<b>Application Ref:</b>	2025/0653			 Ribble Valley Borough Council <small>www.ribblevalley.gov.uk</small>
<b>Date Inspected:</b>	27/8/25	<b>Site Notice:</b>	27/8/25	
<b>Officer:</b>	SK			
<b>DELEGATED ITEM FILE REPORT:</b>				<b>REFUSAL</b>

<b>Development Description:</b>	Variation of condition 2 (Plans) on permission 3/2023/0706 for the proposed erection of 34 Class E(g) units and one battery storage and maintenance unit with associated parking and access. Resubmission of application 3/2022/0553.
<b>Site Address/Location:</b>	Higher College Farm Lower Road Longridge PR3 2YY

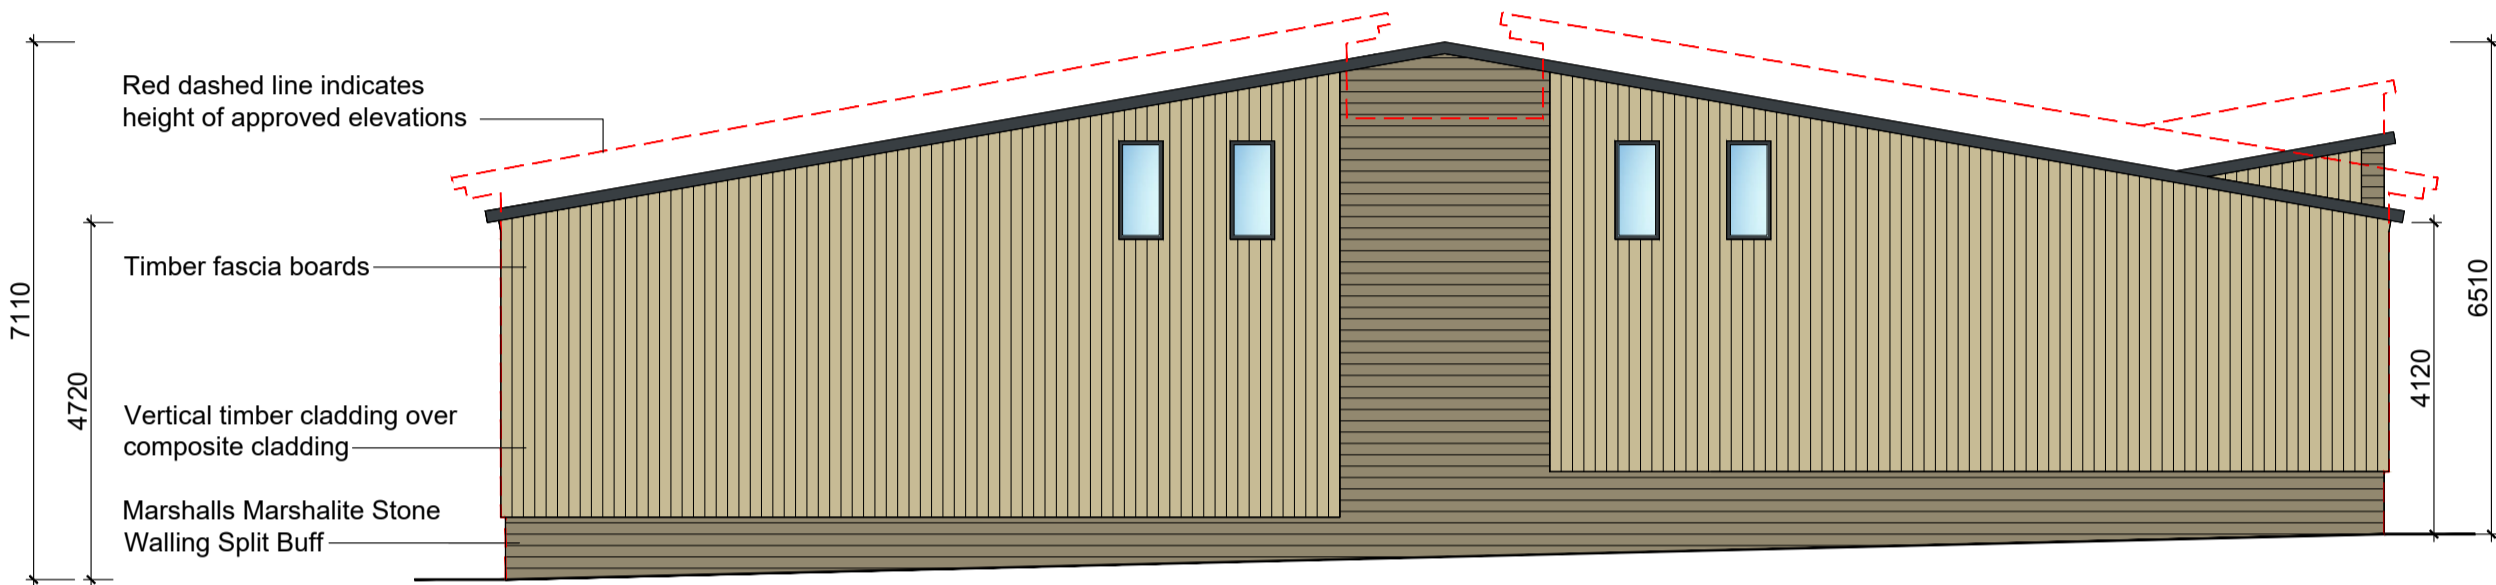
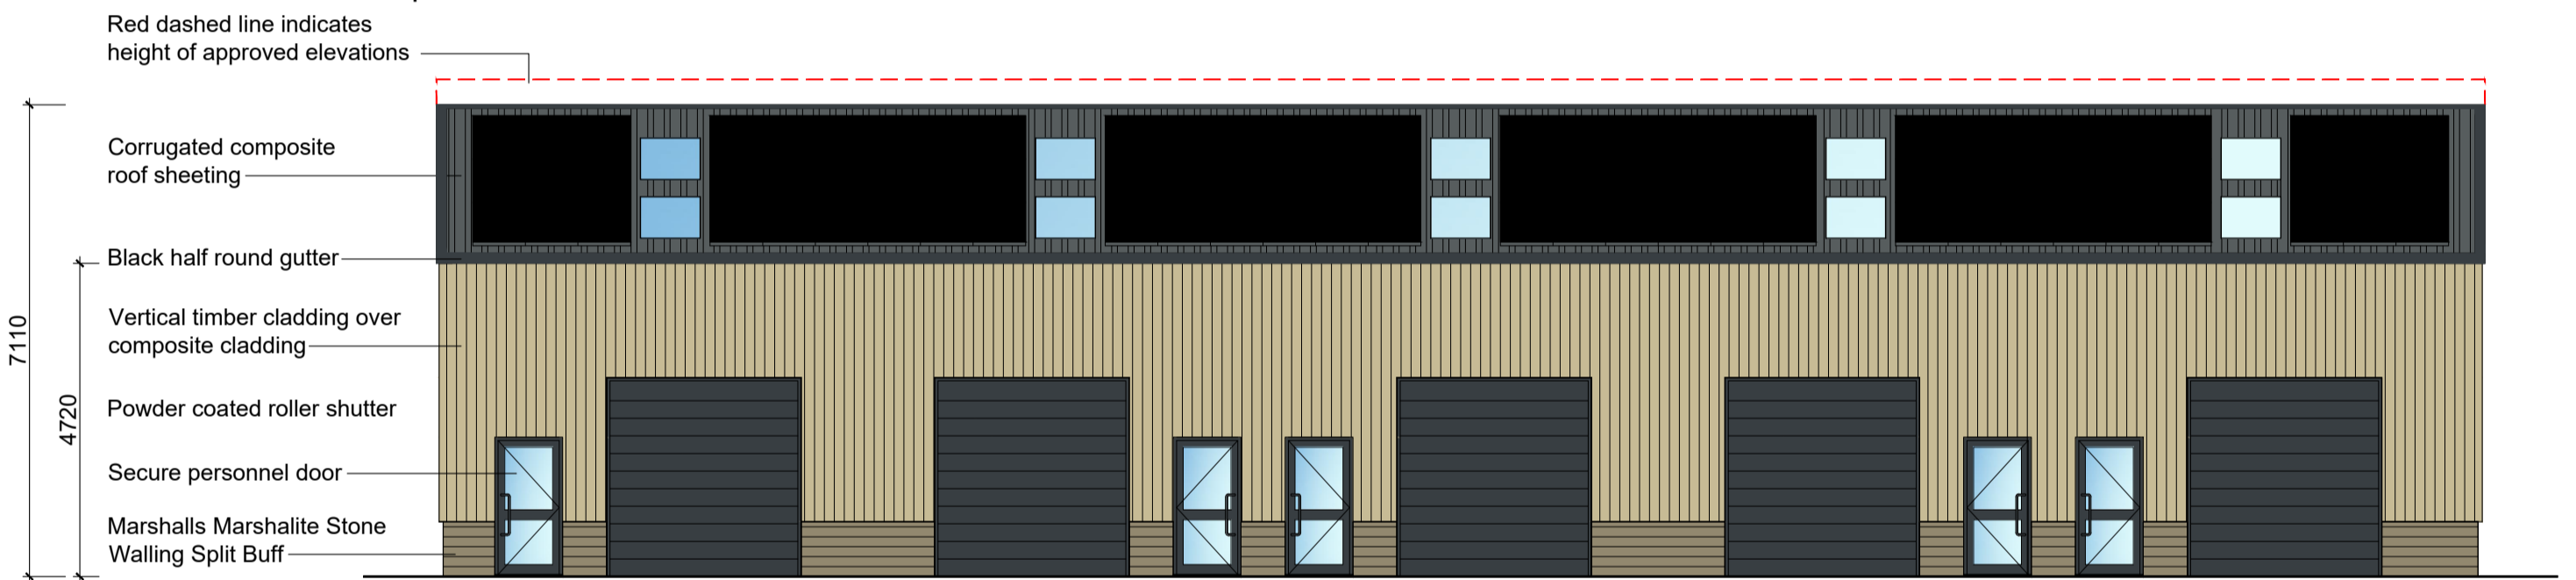
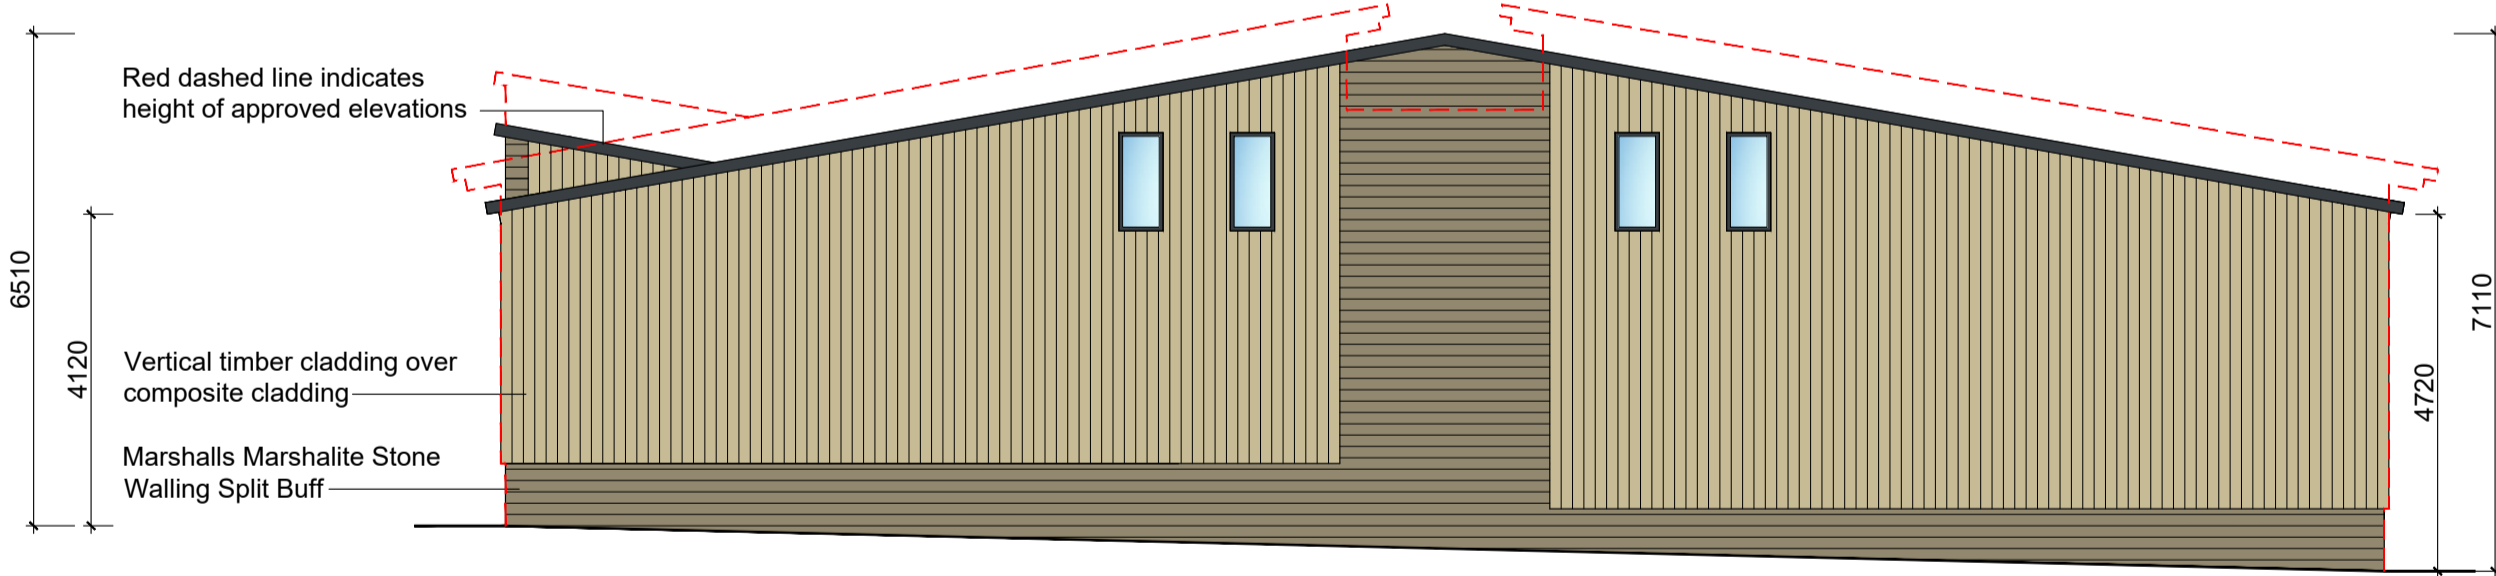
The submitted details seek to vary the originally approved roof-form of the proposed buildings with a slight reduction in height also being proposed. In this respect it is proposed that there will be an overall reduction in eaves and ridge height, the removal of the previously approved recess and associated dual mono pitched roof and a return to a dual pitch roof across each of the buildings.

The previously approved mono-pitch roof-form and central recessed elements were considered to be features that were fundamental to the proposal being supported. With the features allowing the for the overall building mass of each of the buildings to be visually broken down into smaller 'visual components' with the side elevations also possessing an element of visual depth and relief. The dual mono-pitch roof arrangement was also considered to assist in breaking down the overall visual extent of the proposed roof-form, also allowing for greater visual articulation and once again an element of relief and visual interest within the roofscape across the proposal.

In this respect the removal of these elements, whilst it is recognised there will be a slight lowering of the overall ridge and eaves height of the buildings, the overall resultant built-form and overall roofscape across the site will fail to benefit from adequate visual depth or relief, with the buildings adopting an overall stark utilitarian appearance - that would fail to respond positively to the character of visual amenities of the area, being of detriment to the character and visual amenities of the defined open countryside and the immediate area.

Taking account of the above, the proposal is considered to be in direct conflict with Policies DMG1 and DMG2 of the Ribble Valley Core Strategy insofar that approval would result in the introduction of buildings, of an overtly utilitarian appearance, that fail to benefit from adequate articulation or visual interest and fail to respond positively to the inherent character of the open countryside setting of the site, being of significant measurable detriment to the character and visual amenities of the area.
